M^CLAREN TRAFFIC ENGINEERING

Reference: 190701.03FA

TRAFFIC RESPONSE TO FAIRFIELD CITY COUNCIL FOR THE PROPOSED SAINTS PETER AND PAUL ASSYRIAN PRIMARY SCHOOL AT 17 - 19 KOSOVICH PLACE, CECIL PARK, 2178

**RESPONSE TO SUBMISSIONS - PROPOSED SAINTS PETER AND PAUL
ASSYRIAN PRIMARY SCHOOL AT 17-19 KOSOCIVH PLACE, CECIL PARK**

MCLAREN TRAFFIC ENGINEERING
A division of RAMTRANS Australia Pty. Ltd.
Shop 7, 716-720 Old Princes Hwy, Sutherland NSW 2232
Email: admin@mclarentraffic.com.au
Phone : (02) 8355 2440
www.mclarentraffic.com.au

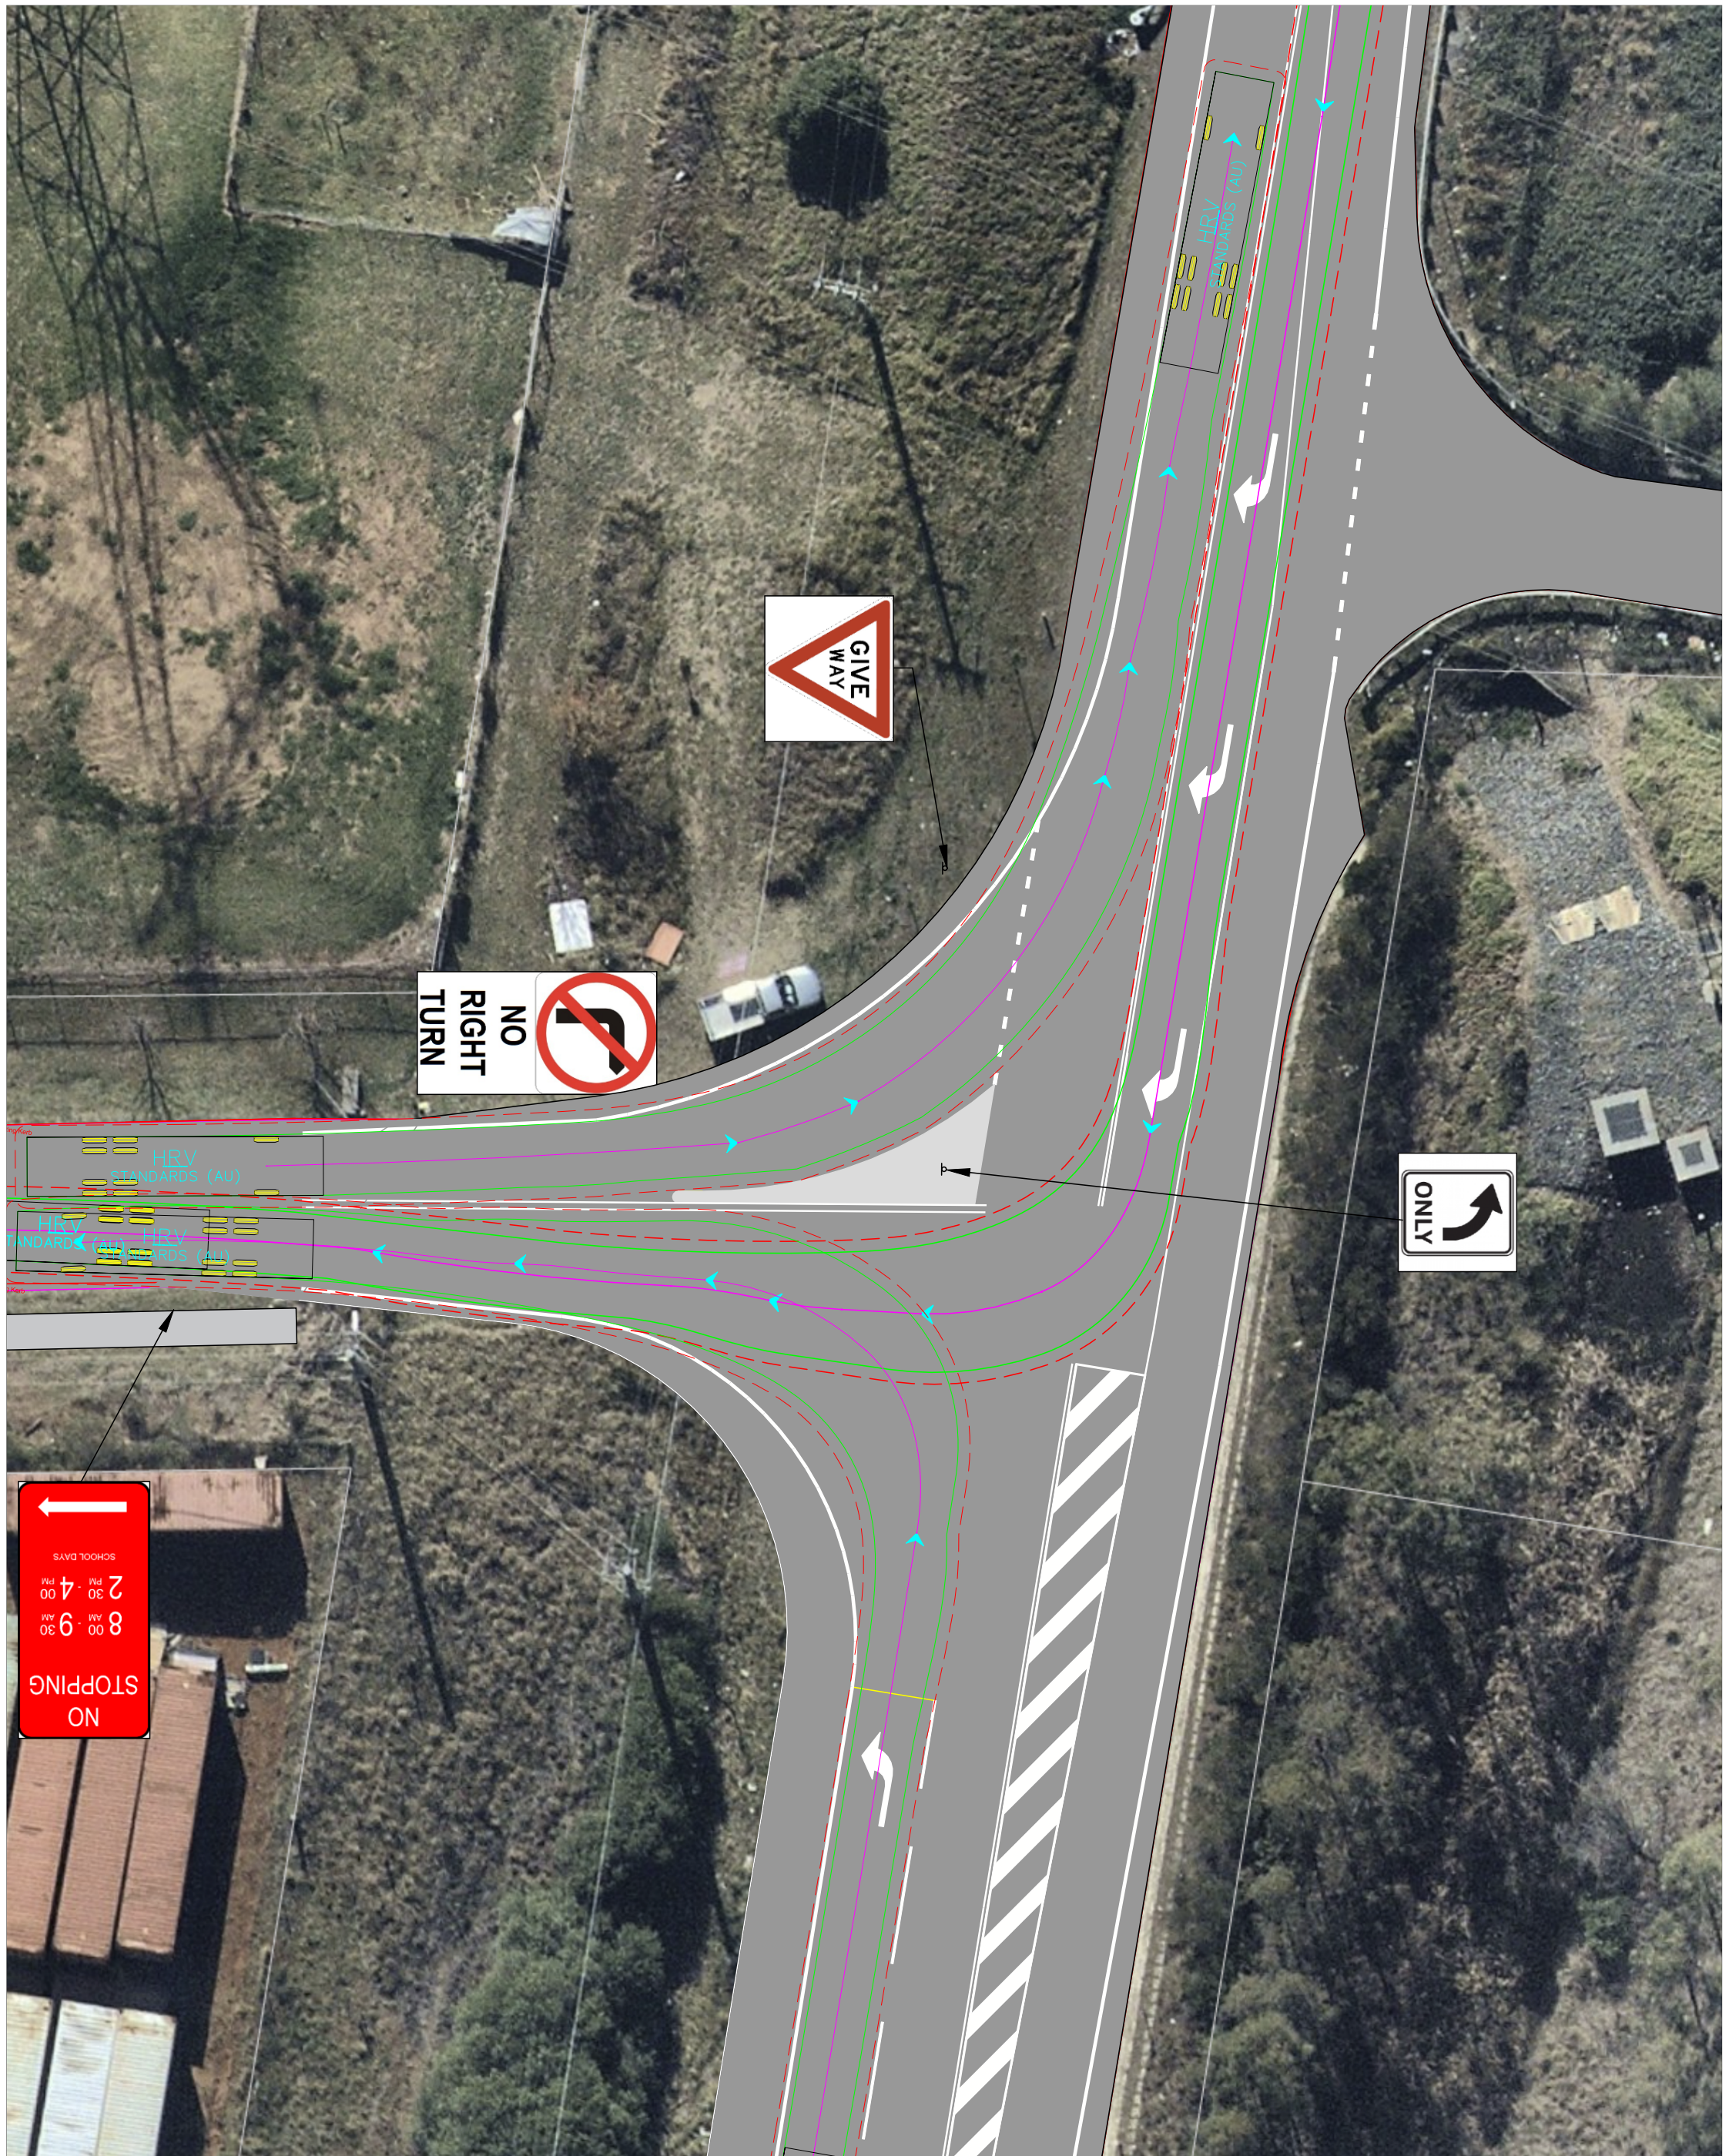
1. The proposed modifications of the intersection of Wallgrove Road/Kosovich Place will be detrimental to traffic safety.
2. The assumed car occupancy of 1.85 children per vehicle is not sufficiently justified and the resulting traffic generation estimated is not accepted.
3. The proposed car parking and kiss and drop facilities are insufficient.
4. The proposed bus parking on Kosovich Place is not justified as it will not benefit other stakeholders.
5. Insufficient information has been provided with regards to the vehicles servicing the site.

The proposed auxiliary right-turn lane on Wallgrove Road into Kosovich Place and 'No Right Turn' restriction from Kosovich Place into Wallgrove Road is considered a safety hazard for motorists at the intersection and to school children. RMS recommend that a roundabout be proposed at the intersection to improve the safety of turning traffic at Kosovich Place/ Wallgrove Road; it will also benefit the safety of the road network by reducing the approach speed by motorists.

It should be noted that extensive consultation with RMS is ongoing and that RMS accepts that a roundabout is not a viable treatment for this intersection due to the physical constraints present. The placement of school-zone signage will occur along Kosovich Place as agreed with RMS.

The proposed modifications to the intersection of Kosovich Place/Wallgrove Road include the following changes as shown on the plans reproduced in **Annexure B**:

- A 26.6m long auxiliary lane providing for the storage of vehicles waiting to turn right from Wallgrove Road into Kosovich Place:

- It is noted that this does not include the taper length of 18m.
- This length is the longest lane length that can be accommodated considering the proximity of the roundabout to the north and the narrow culvert across Ropes Creek.

- A 26.6 long lane is sufficient to accommodate the 98th percentile queue predicted by SIDRA analysis sensitivity testing and can accommodate two 12.5m long Heavy Rigid Vehicles.

- A 100m long (including taper) auxiliary lane providing for the deceleration of vehicles turning left into Kosovich Place.
- “No Right Turn” and “Left Only” signage, complemented by a concrete island, restricting right turns out of Kosovich Place.
- Lane and shoulder widths generally matching the existing geometry of Wallgrove Road;
- All intersection turns designed to accommodate a 12.5m long Heavy Rigid Vehicle.
